Subject: RE: BE/117/18/DOC - Discharge of Conditions 5, 6, 14 + 23 - New Barn Lane, North Bersted

Subject: RE: Discharge of Condition 5 BE/18/17/PL - New Barn Lane, North Bersted

Condition 5 (surface water drainage)

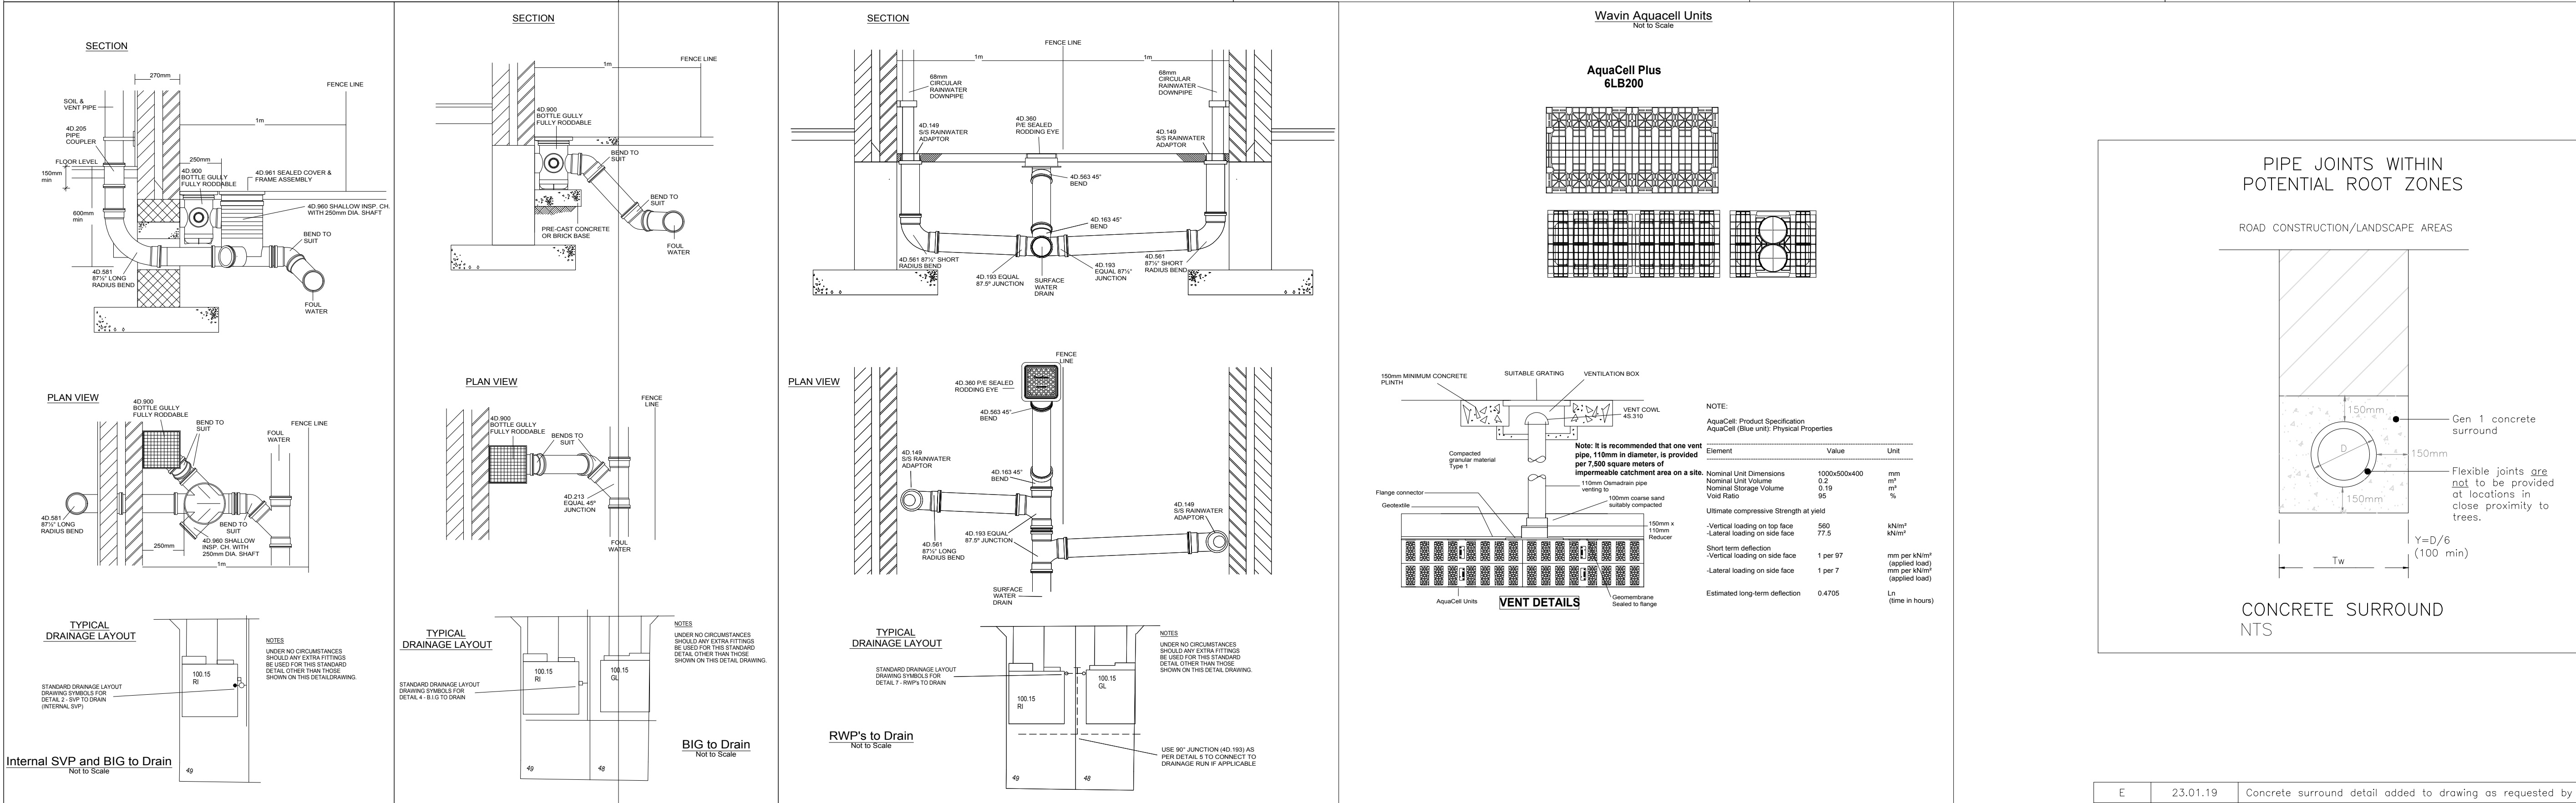
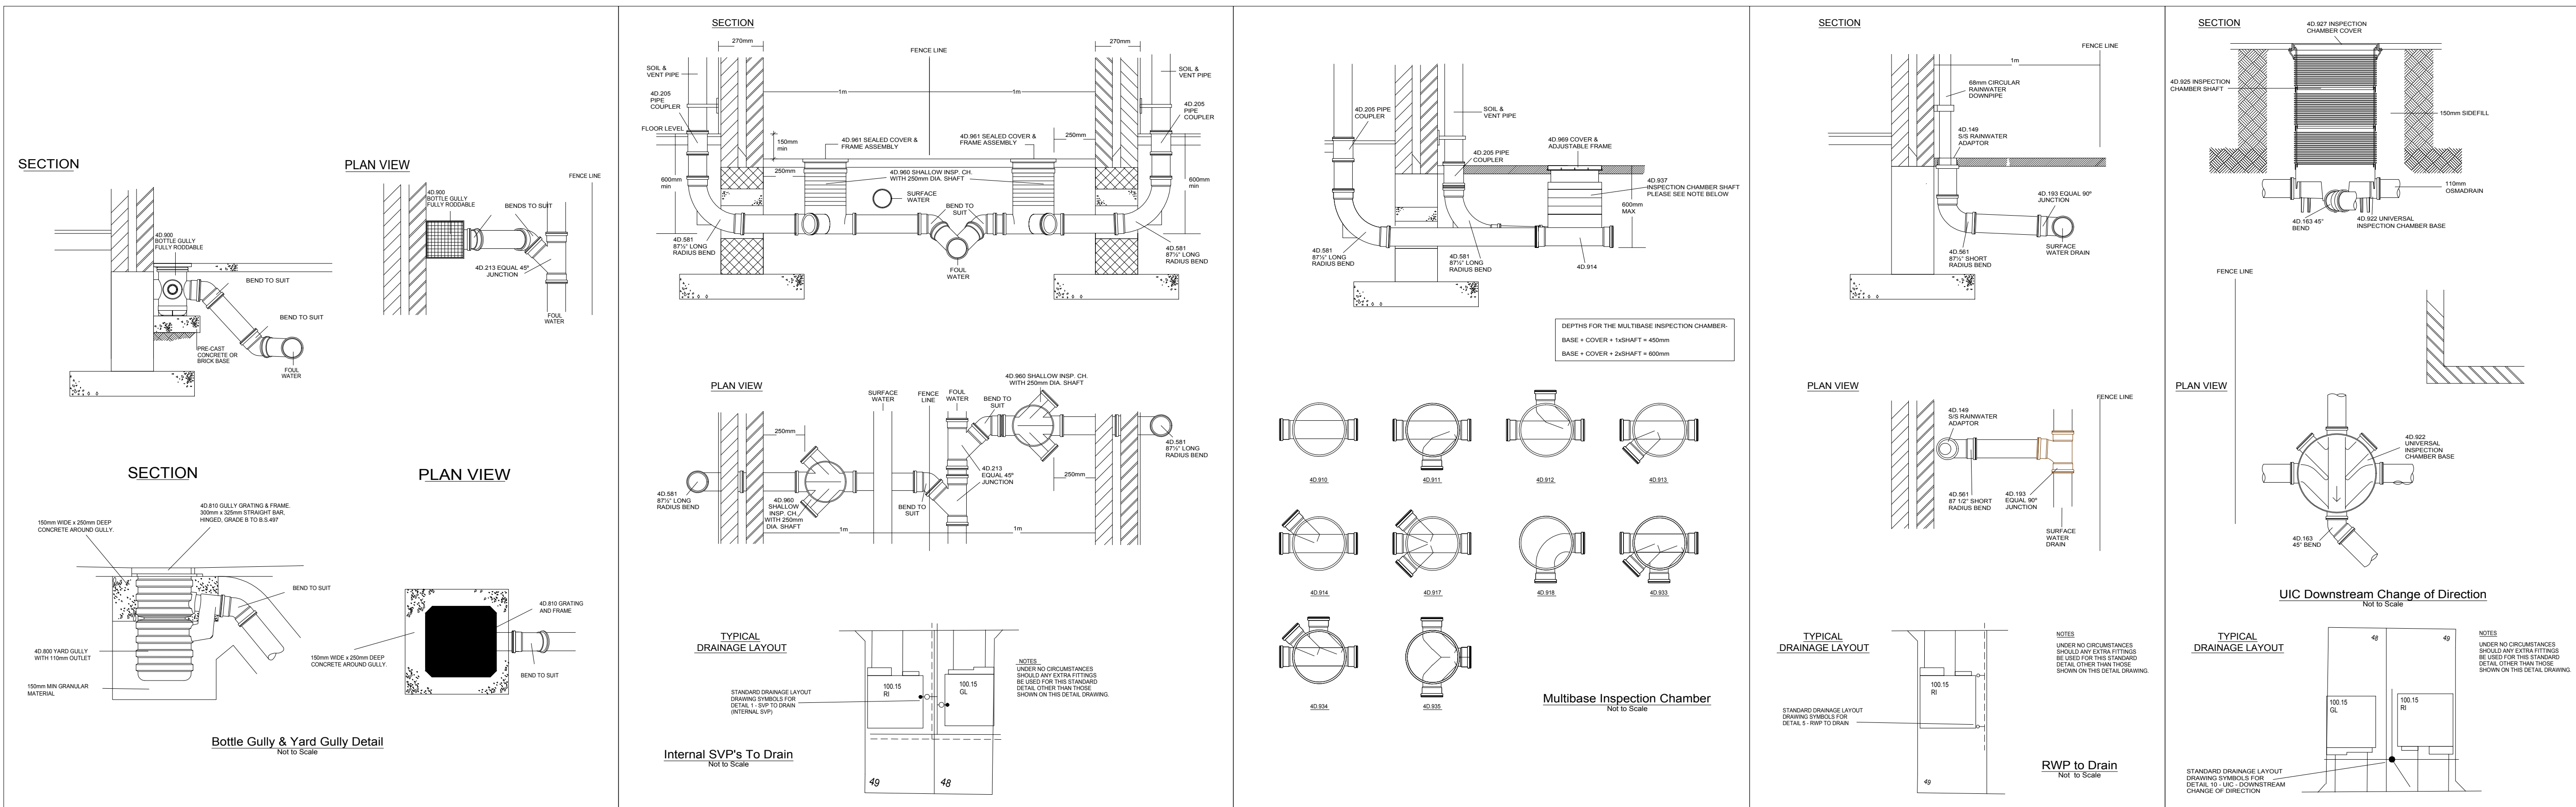
4. 150mm concrete bed and surround will need to be provided at all pipes joints within potential root zones.

MJA Response—Concrete surround detail is located in Drawing LHS232-1021 (enclosed). This concrete bed and surround detail is for standard bedding, it does not state that the flexible joints are not to be provided at locations in close proximity to trees. Can you please add a specific detail and note to a surface water sewer construction detail sheet.

MJA Response—Noted, concrete surround detail added to Drawing LHS232-1022 revision E; Okay.
